PLANNING APPLICATION FP/46/19/PL- PROPOSED EXTENTION AND ALTERATIONS AT 28 SEA DRIVE

With reference to planning application FP/46/19/PL of Date 25th February 2019 I would like to report a discrepancy between two of the plans and would like to put it on record.

PROPOSED SOUTH ELEVATION 1:100

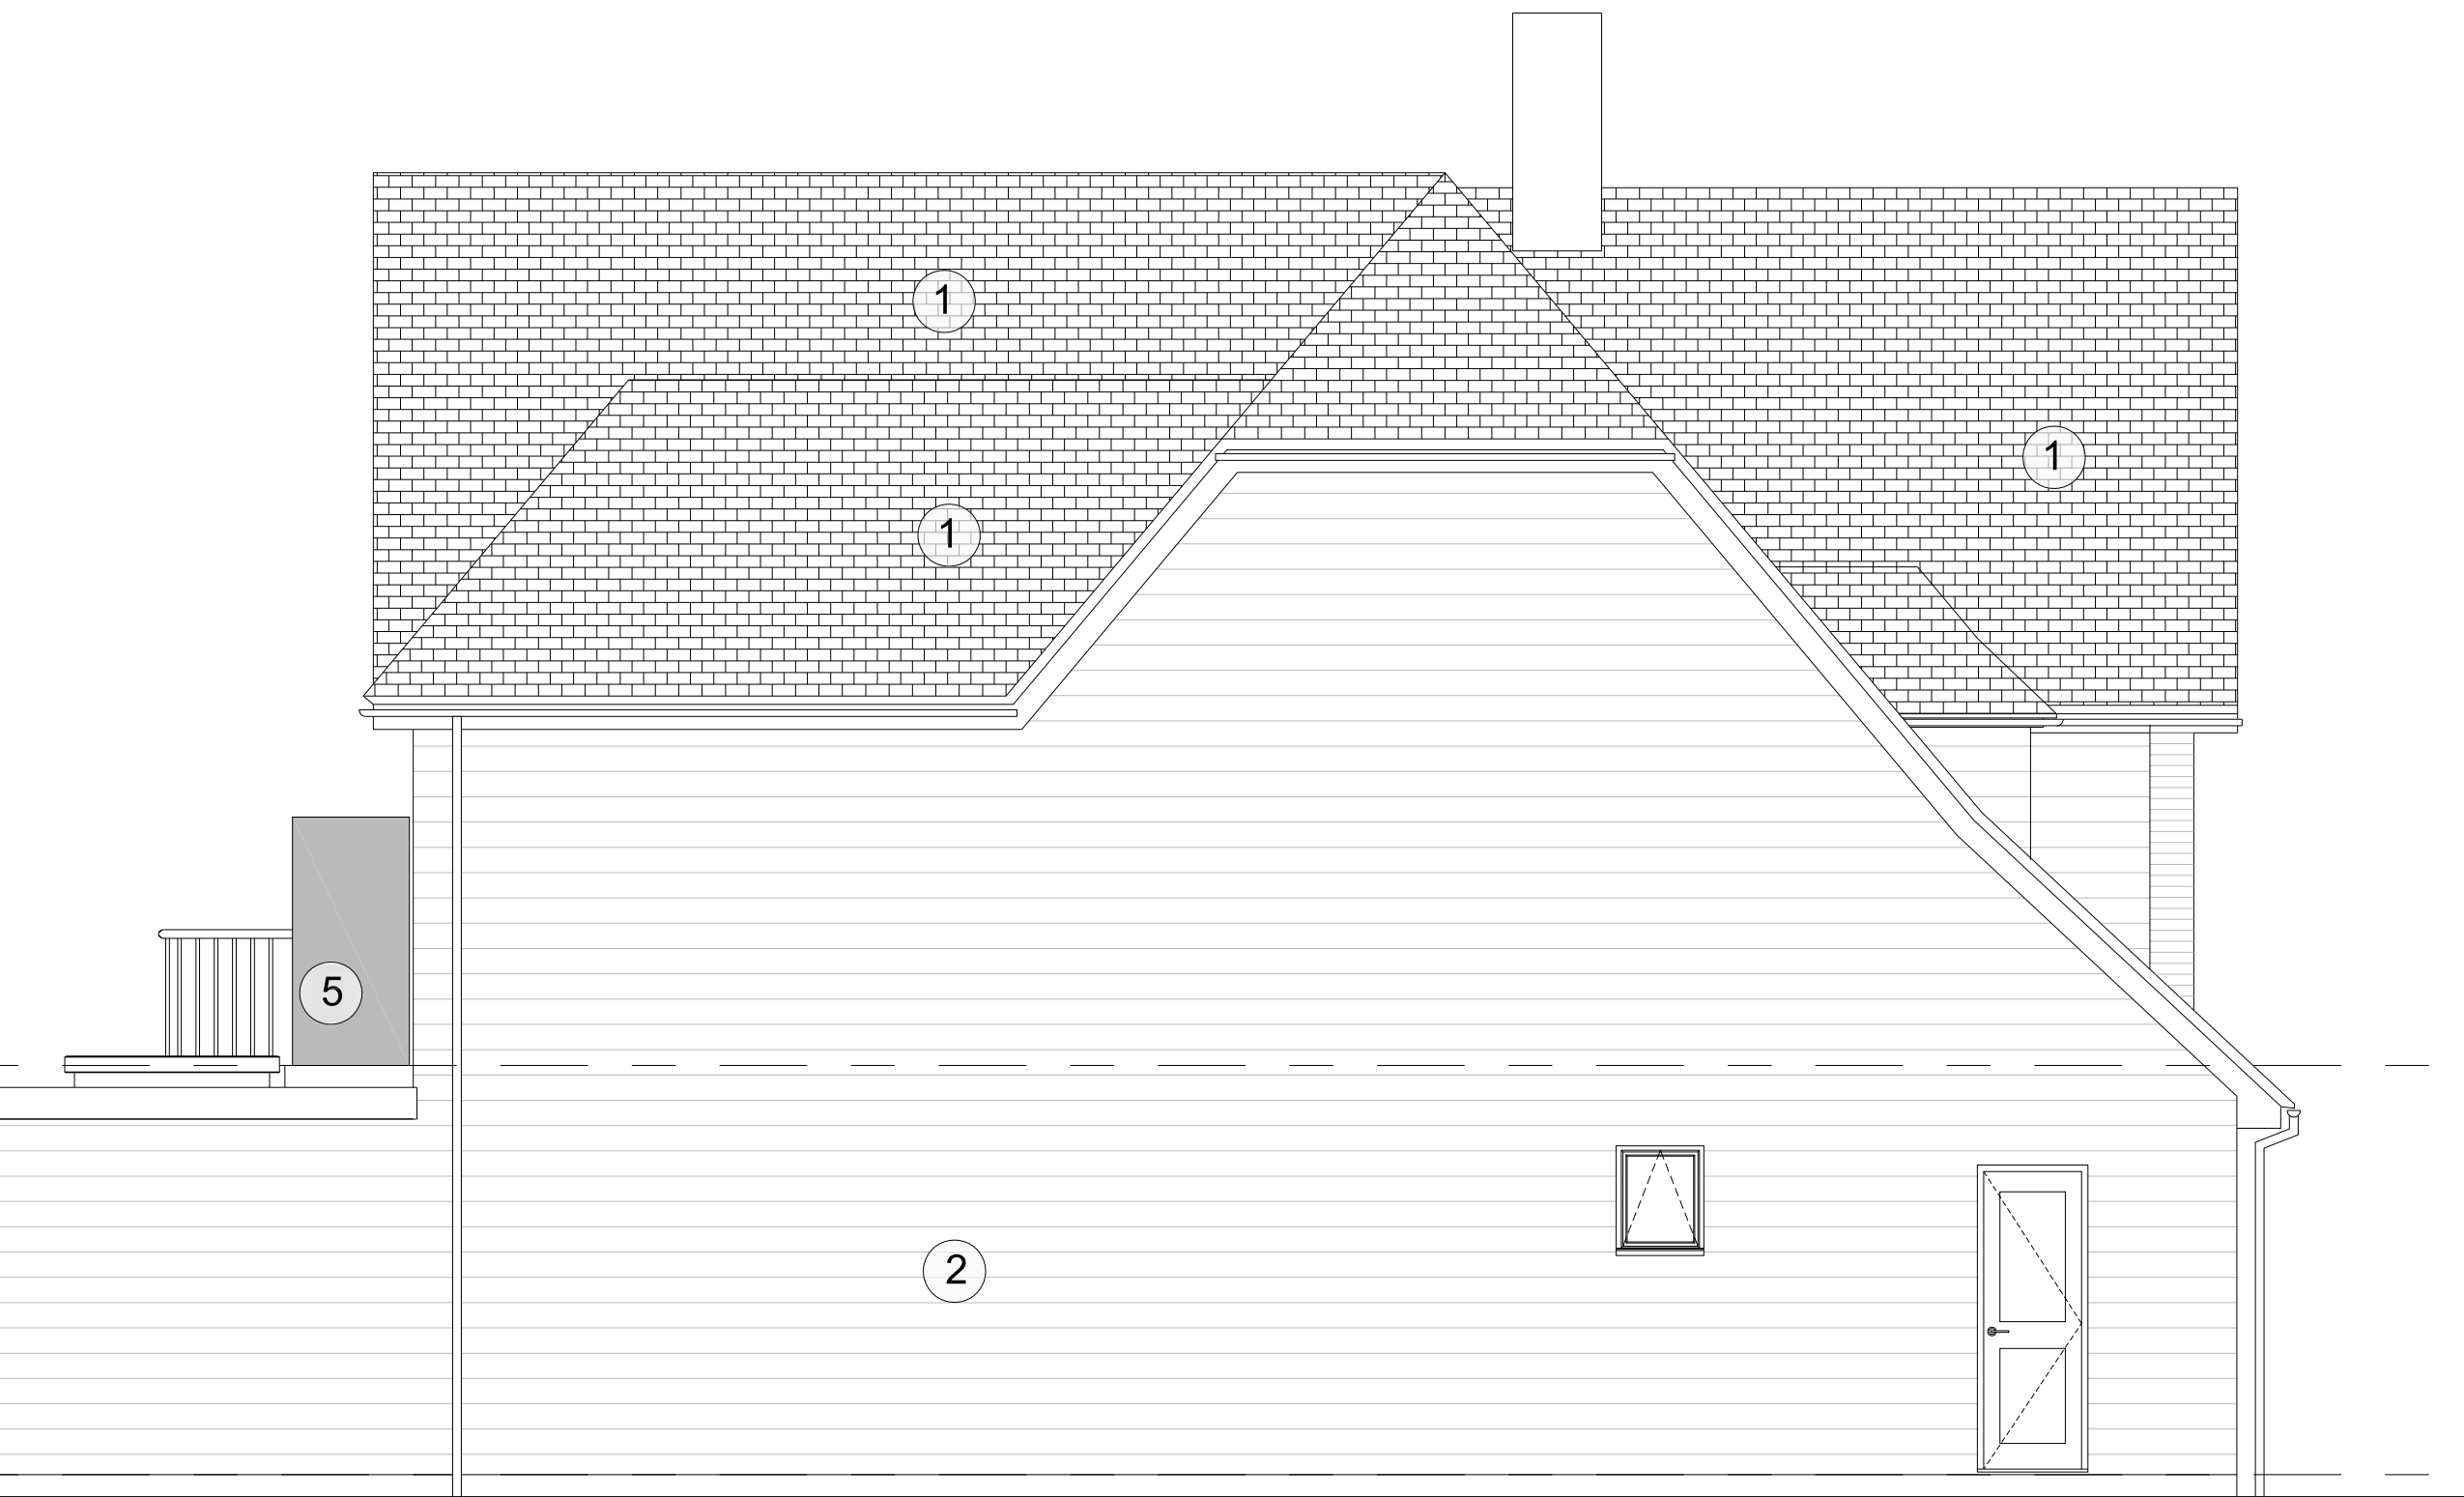
Whilst reviewing the said planning application via the Arun District Council Planning on-line portal, I noticed a discrepancy between the Existing and Proposed Block Plan B (which is an amendment to an existing consent A) and the Proposed Elevation Plan, specifically the South Elevation.

I would like to draw to your attention the hatched area showing the exact floor area of the balcony on the Block Plan B, which is different to the balcony detail found on the South Elevation Drawing, where by the balcony is much longer and almost the length of the entire south elevation. *(Please refer to the below Annex A and Annex B for further understanding)*

The "Existing and Proposed Block Plan B" and the "Proposed Elevation Plan (South Elevation)" are conflicting and as such the application ought to be withdrawn and amended so that all the documents/ plans are accurate and represent the exact true proposal of the Extension and Alterations works at 28 Sea Drive.

My concern is that the balcony shown in the Proposed Elevation Plans (South Elevation) is in close proximity to my boundary line and I'm worried my daily enjoyment of my garden will be affected.
